From: Sue Howell
Sent: 23 February 2015 13:50
To: Planning.Responses
Cc: Neil Crowther
Subject: RE: Planning Consultation on Y/9/15/DOC

Comment from Greenspace

Y/9/15/DOC

Land Associated with Rookery Farm North of
A259 Flansham PO22 8NN

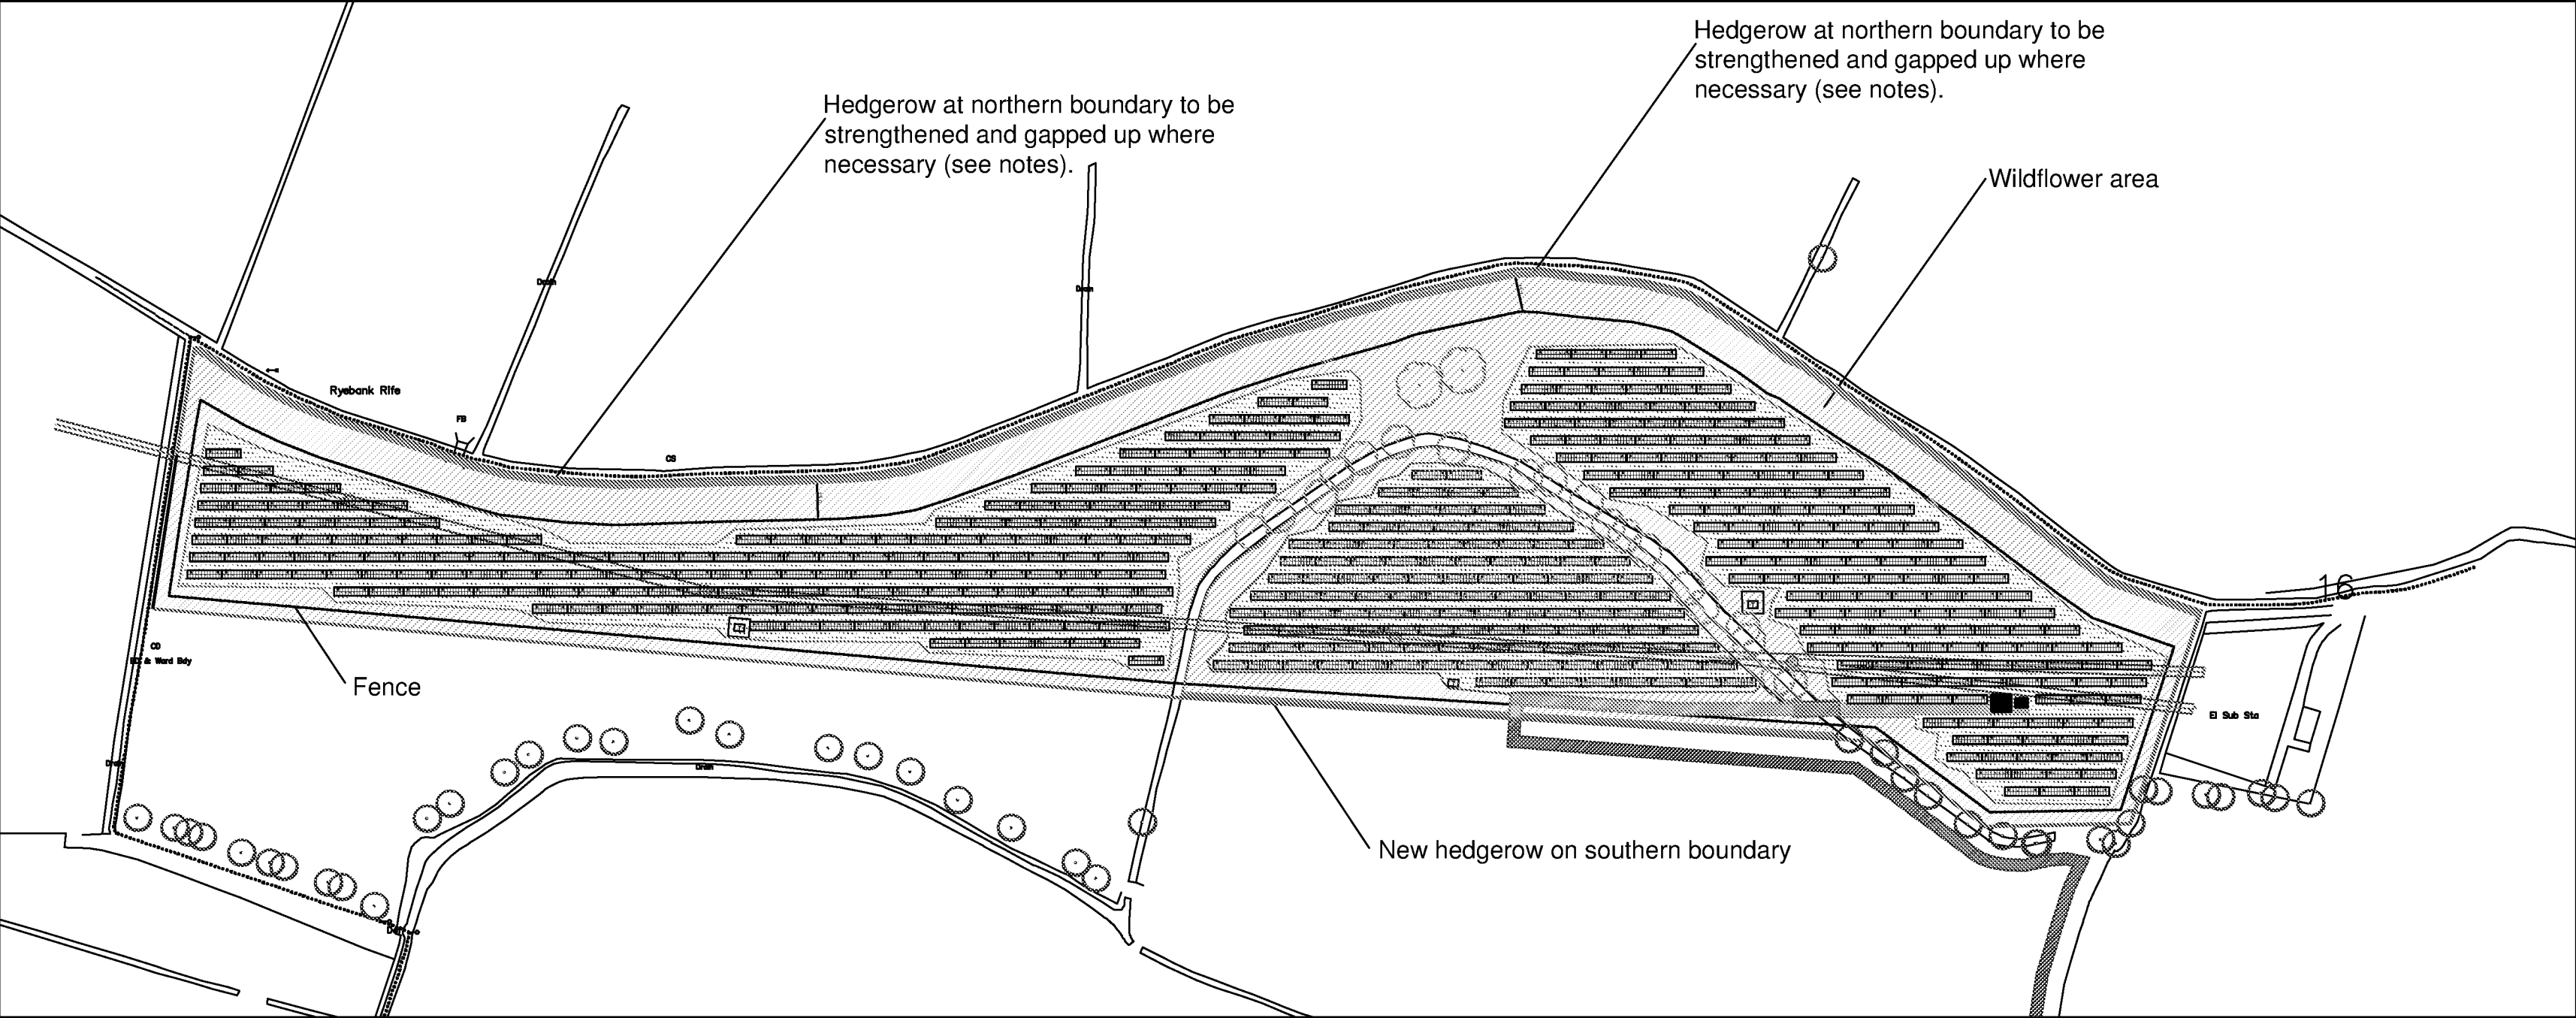
Landscape drawing LE12330-001 details areas to be planted and areas to be infilled along with an indicative species mix which does indicate size at time of planting and densities. **However** this plan is only indicative and needs to show this information plotted on the drawing with actual planting quantities rather than just the stated percentage composition.

We would not be able to recommend the discharge of Condition 10 on this application until the above information has been supplied for approval.
